Ref: 1244/371/04

Orica Southlands - Modification 1 (MP 06_0919) – Response to Submissions

Orica Southlands - Modification 1 (MP 06_0919) – Response to Submissions

Southlands Industrial Estate **Figure D9a**
Final Development Scenario 50% AEP flood level difference map

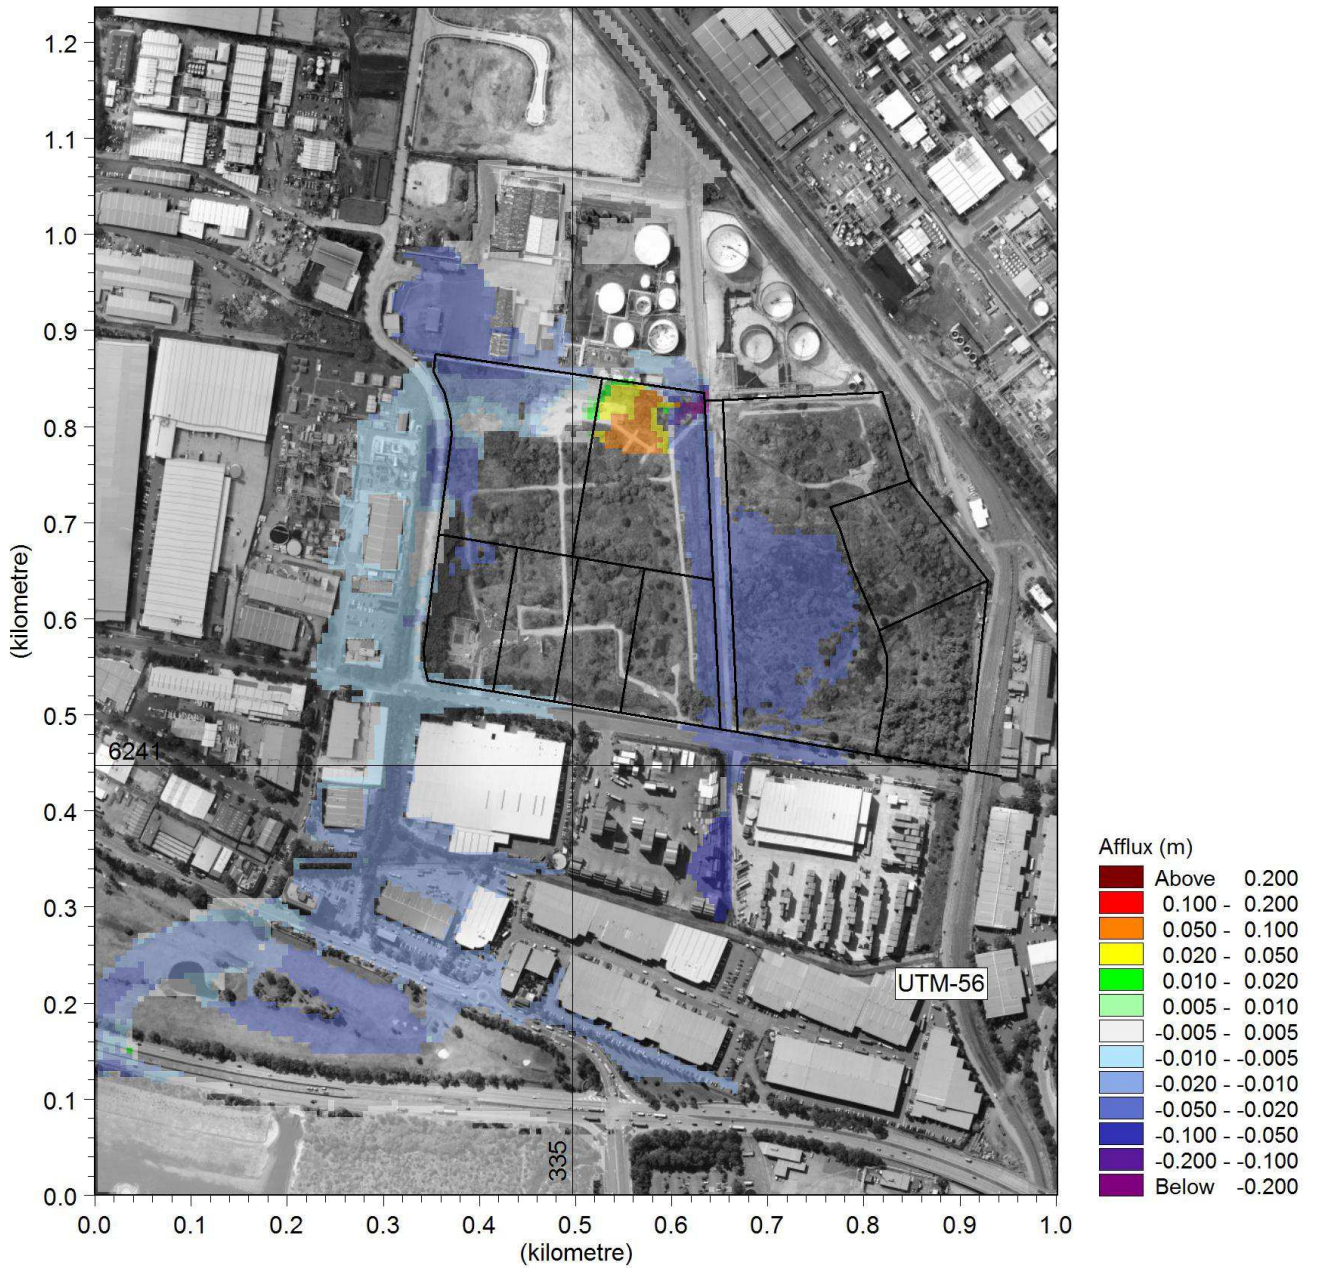
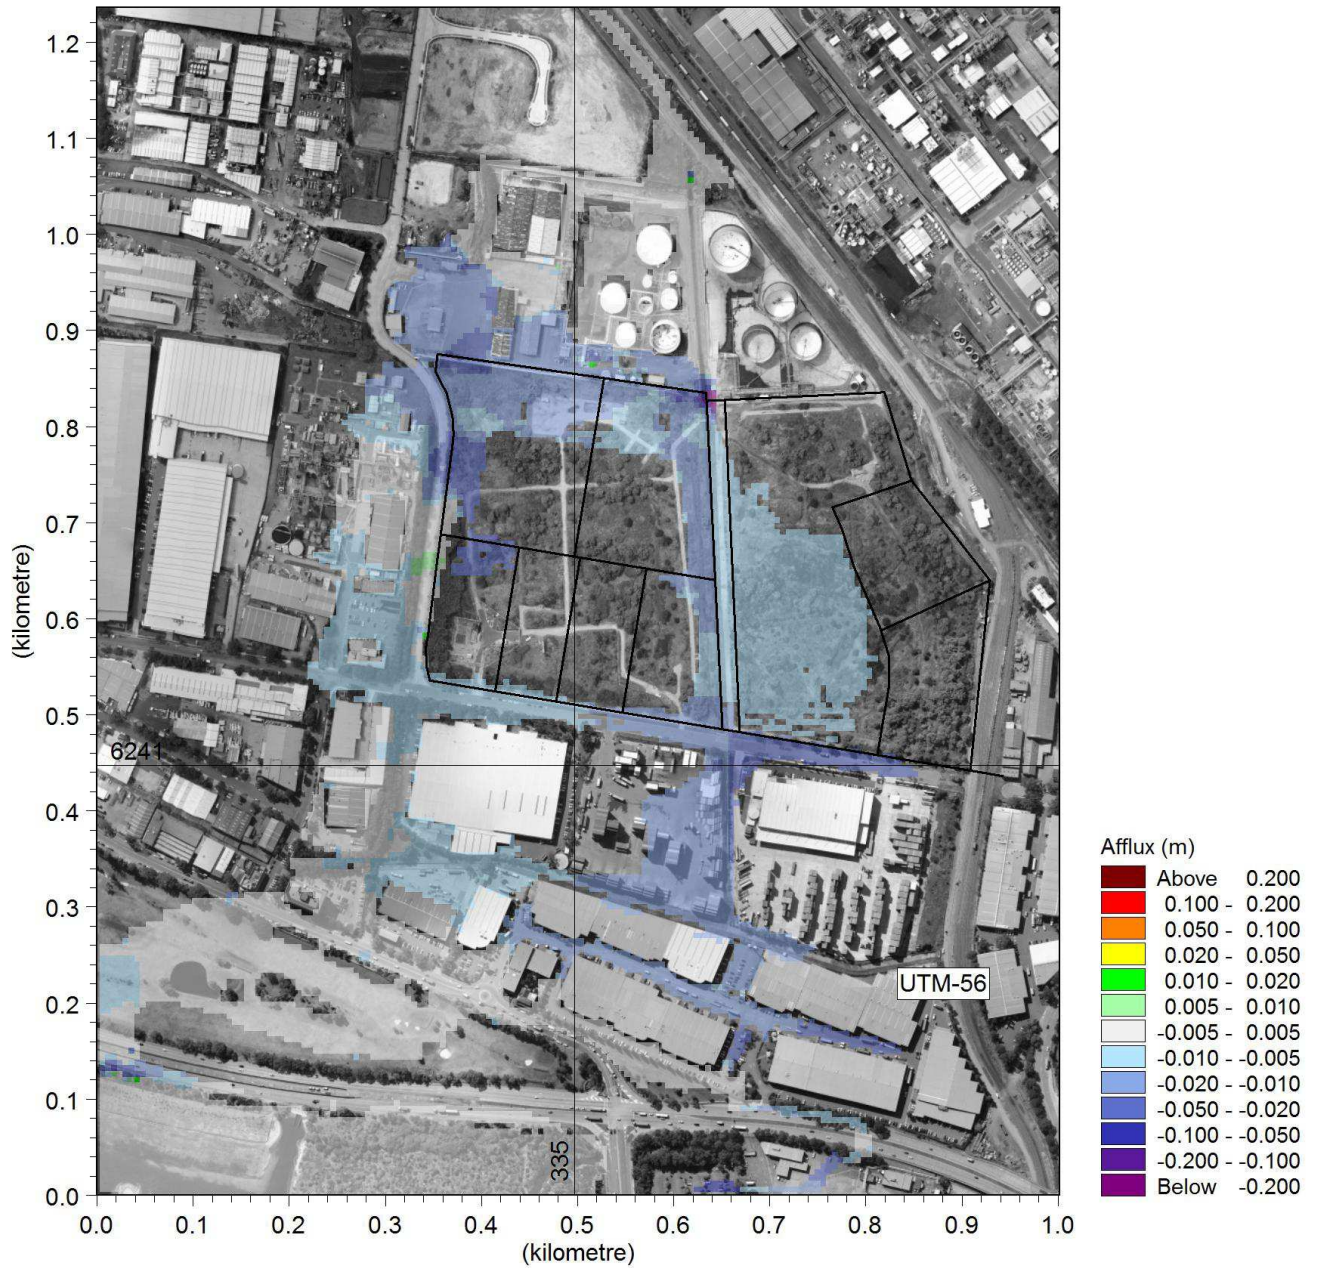
Flood Study	<p>The basis of the Aurecon flood modelling is outlined in the earlier Aurecon Report which forms part of the original Consent documents - <i>Orica Southlands Remediation and Development Project Hydraulic Modelling Report and Response to Exhibition Submissions/Comments – (Report Ref: 204617, 29th November 2010, Revision 3 by Aurecon.</i> This latest advice from Aurecon therefore relies on the earlier report and the flood model parameters established in that report.</p> <p>The only changes to the current modelling are the topography and roughness parameters in the areas where changes to the earthworks design have occurred, with all other parameters remaining the same. The previous report therefore remains relevant in terms of parameters, and the latest Aurecon advice is an addendum to that report.</p> <p>In terms of flood impact we note that the Orica Compensatory Flood basin was never meant to solve the existing flood situation in the area. We are aware that adjoining properties have built below the 1:100 year flood level but the Southlands site cannot solve this situation. Rather the agreed design parameters for the flood storage area agreed with the DoPI was to achieve a situation where the development of the Southland site did not exacerbate existing flooding on adjoining sites (by no more than 10mm - agreed as a measure of accuracy within the modelling). The modified basin configuration continues to meet that requirement.</p> <p>The updated difference plans prepared by Aurecon (attached as Drawings 9a – 11a) (Attachment D) show the difference between the proposed flood levels at the various</p>

<p>storm events compared to the existing. This clearly shows that the modified basin continues to meet the agreed parameters of no additional flood impact on adjoining lands.</p> <p>Aurecon do advise that there is a difference on adjoining land between the modification and the approved plans that benefit some properties and increase flood levels on others by up to 20mm in the 1:100 year event (see Attachment H which shows the change in levels compared to the approved drawings for the 1% event). However, all sites continue to have no greater flood impact than the existing case – ie current flood conditions, as shown in Attachment D.</p> <p>The area now proposed as Lots 7, 8 and 12 are generally shown in an area that is already above RL4.2 (which is the maximum 1 in 100 year flood level across the Southlands site) and not subject to 1:100 flooding currently. Accordingly the flood difference mapping will correctly show no change to afflux levels in this area.</p> <p>We understand that the DoPI is referring the revised flood modelling to the independent reviewer as was the case with the Project Approval.</p>

| FOR APPROVAL                           |              |                 |                      |
|----------------------------------------|--------------|-----------------|----------------------|
| Drawing Number<br><b>210094-DA-001</b> |              |                 | Revision<br><b>D</b> |

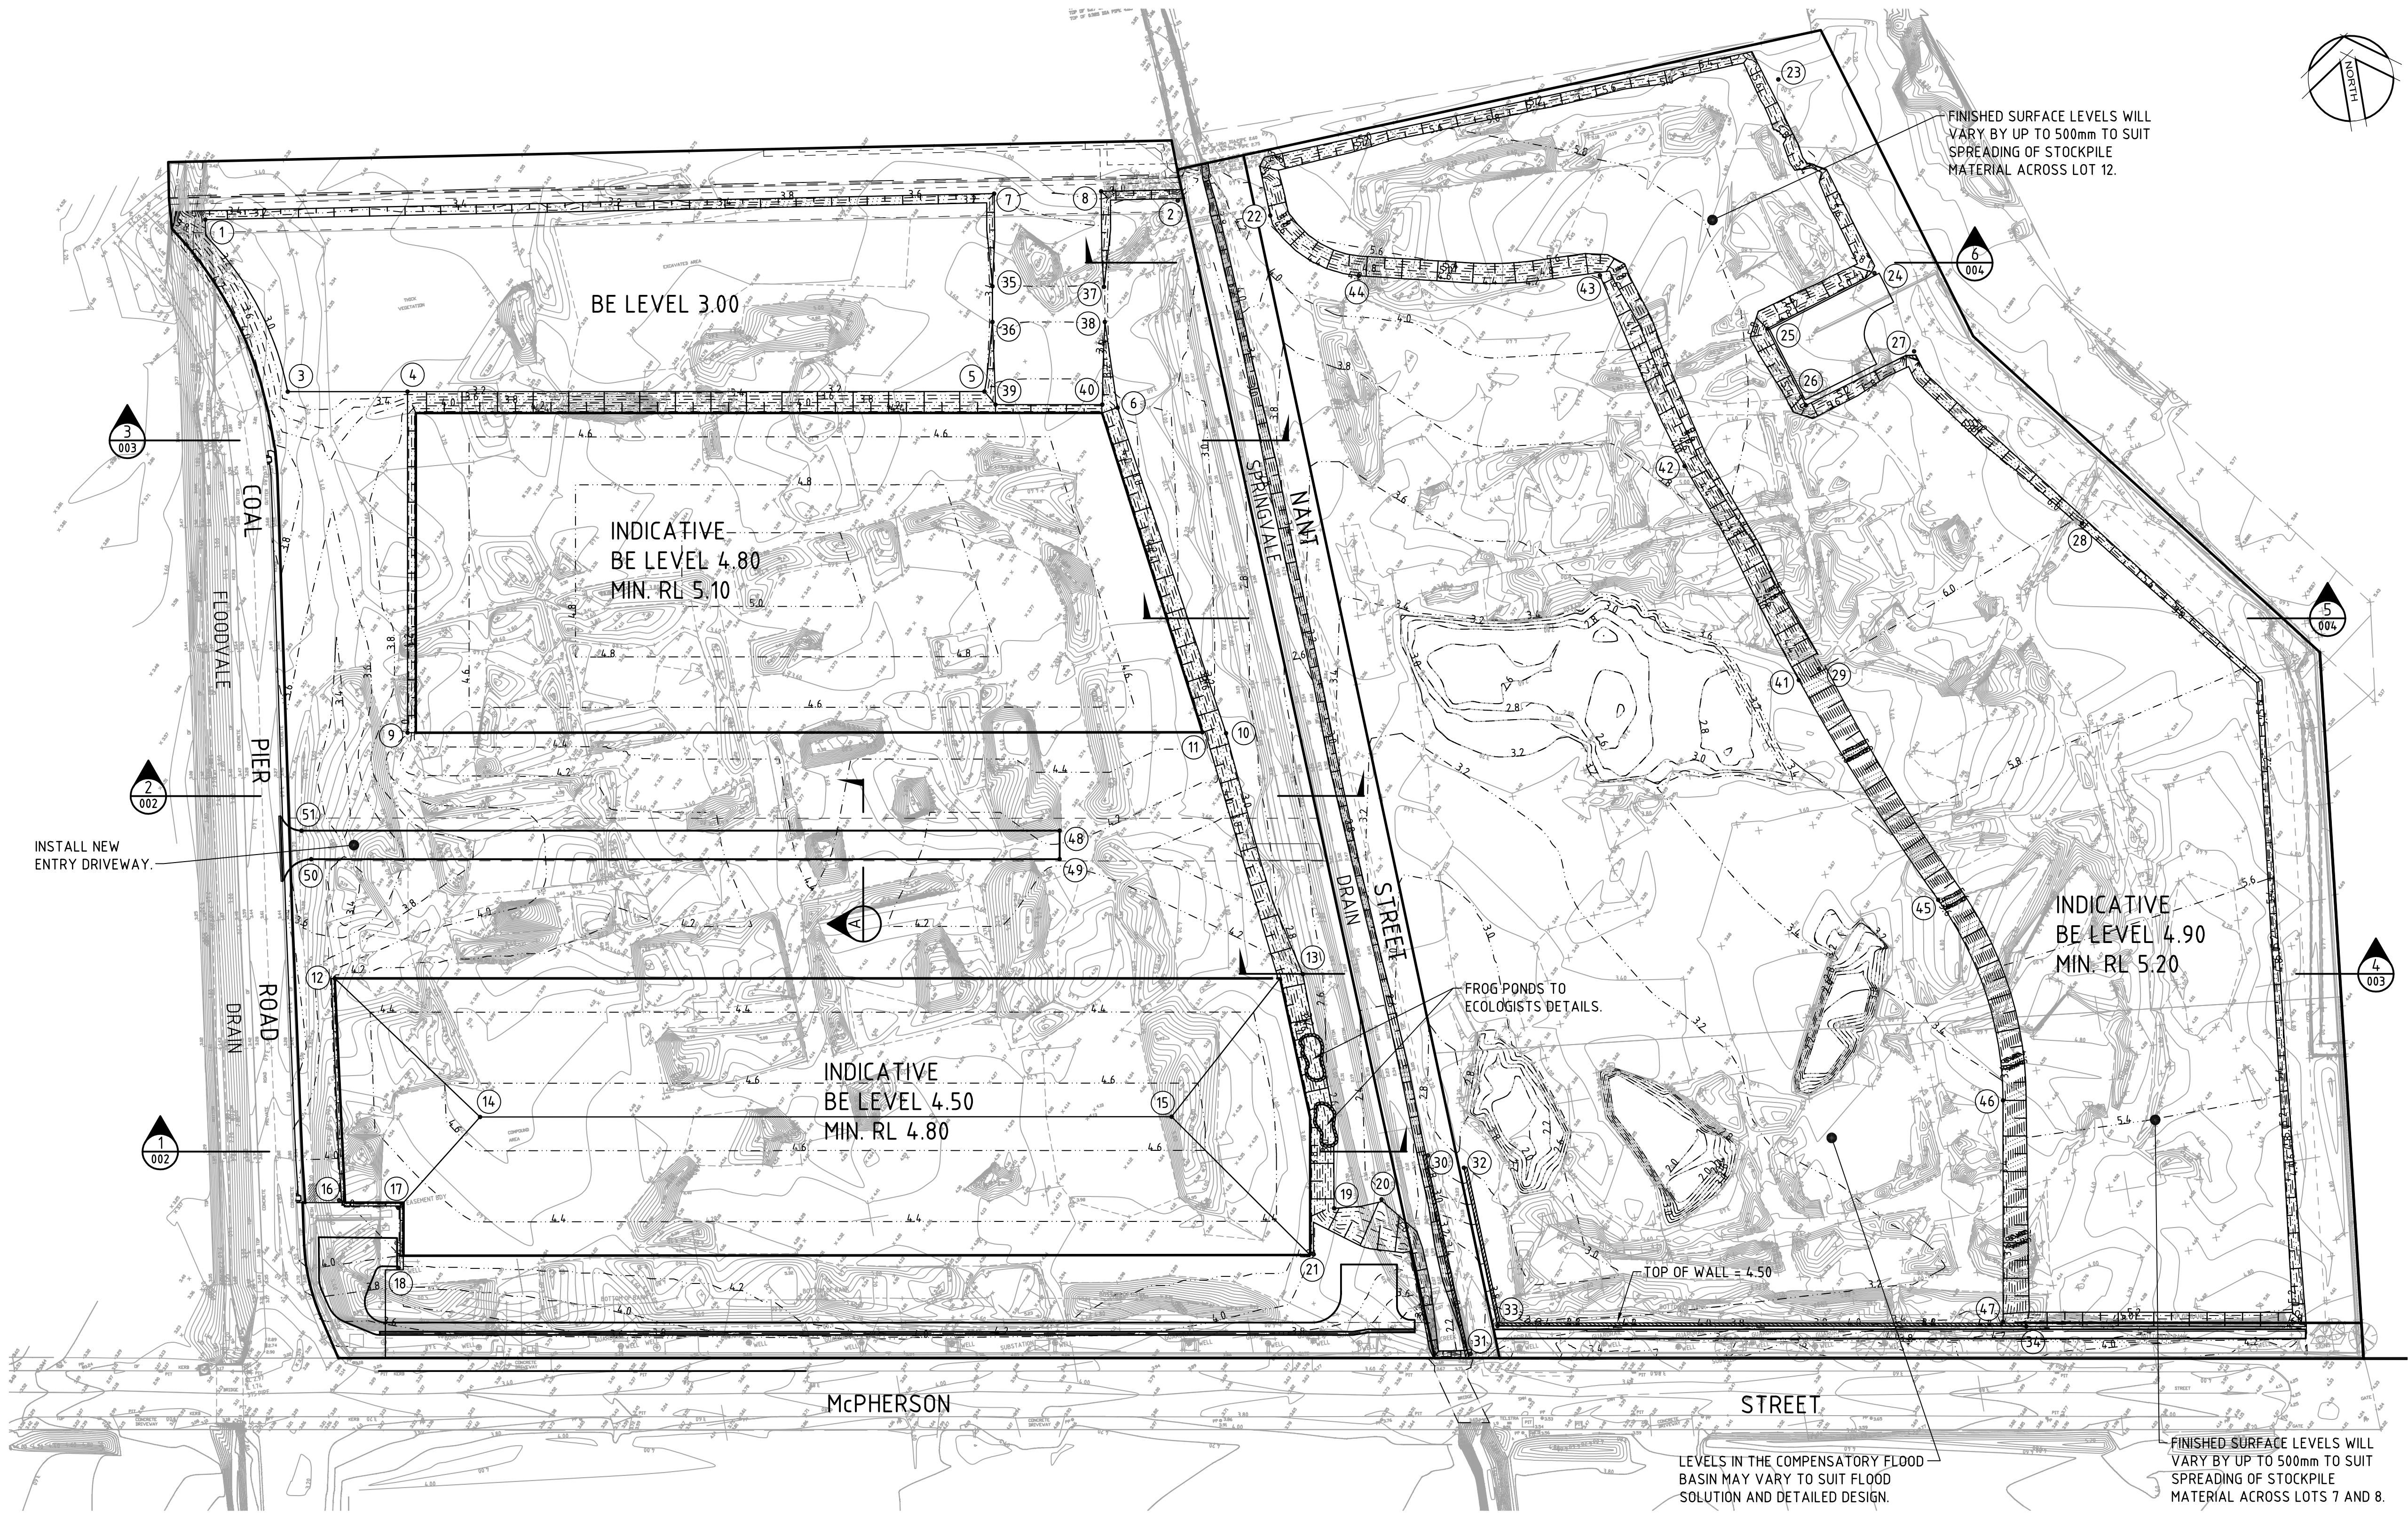
<p>Flood storage basin</p>	<p>The “weir” outlet approved in the current consent was defined by the accompanying Aurecon flood report (Aurecon Flood Modelling Report – Orica Southlands Remediation and Development Project Hydraulic Modelling Report and Response to Exhibition Submissions / Comments – (Report Ref: 204617, 29th November 2010, Revision 3 by Aurecon) as follows:</p> <p><i>All variables have been maintained other than the introduction of a level control structure approximately 25m upstream of McPherson Street on Springvale Drain. The weir is effectively a constriction to reduce the channel width to 3m between the bed and an elevation of 3.2m AHD (approximate bank level by the construction of wing walls that extend into the bank). This allows low flows to be maintained with relatively little impact while larger flows are diverted into the detention basin through raising the water level.</i></p> <p>The latest flood modeling maintains the restriction in Springvale Drain at a location approximately 25 metres upstream of McPherson Street. This area is to be reinforced with a reno mattress structure as shown on drawings included at Attachment G.</p> <p>The restriction will also be armoured with additional rock riprap armouring to improve stability around the restriction. The rock armouring (350mm thick using D50=200mm rock on Bidim A44) was calculated based on the estimated 100 year flow velocity. This in turn means that the potential for scour is also relatively low, when compared to a swiftly flowing stream. Our engineers (Cardno) advise that this is best practice.</p> <p>The McPherson Street culverts create an existing control and there is has never been any proposal by Orica to amend these culverts.</p> <p>Plans showing the control point (the constriction) are included at Attachment G and have been issued to Botany Bay City Council for review.</p> <p>We have also forwarded requested plans of the Water Surface Levels for the 2 year, 10 year and 100 year ARI events to Council and copied them to the DoPI. Similarly we have forwarded the requested sections of the northern channel directly to Council and copied them to the DoPI.</p>

<p>Ref: 204617, 29th November 2010, Revision 3 by Aurecon) as follows:</p> <p><i>All variables have been maintained other than the introduction of a level control structure approximately 25m upstream of McPherson Street on Springvale Drain. The weir is effectively a constriction to reduce the channel width to 3m between the bed and an elevation of 3.2m AHD (approximate bank level by the construction of wing walls that extend into the bank). This allows low flows to be maintained with relatively little impact while larger flows are diverted into the detention basin through raising the water level.</i></p> <p>The latest flood modeling maintains the restriction in Springvale Drain at a location approximately 25 metres upstream of McPherson Street. This area is to be reinforced with a reno mattress structure as shown on drawings included at Attachment G.</p> <p>The restriction will also be armoured with additional rock riprap armouring to improve stability around the restriction. The rock armouring (350mm thick using D50=200mm rock on Bidim A44) was calculated based on the estimated 100 year flow velocity. This in turn means that the potential for scour is also relatively low, when compared to a swiftly flowing stream. Our engineers (Cardno) advise that this is best practice.</p> <p>The McPherson Street culverts create an existing control and there is has never been any proposal by Orica to amend these culverts.</p> <p>Plans showing the control point (the constriction) are included at Attachment G and have been issued to Botany Bay City Council for review.</p>
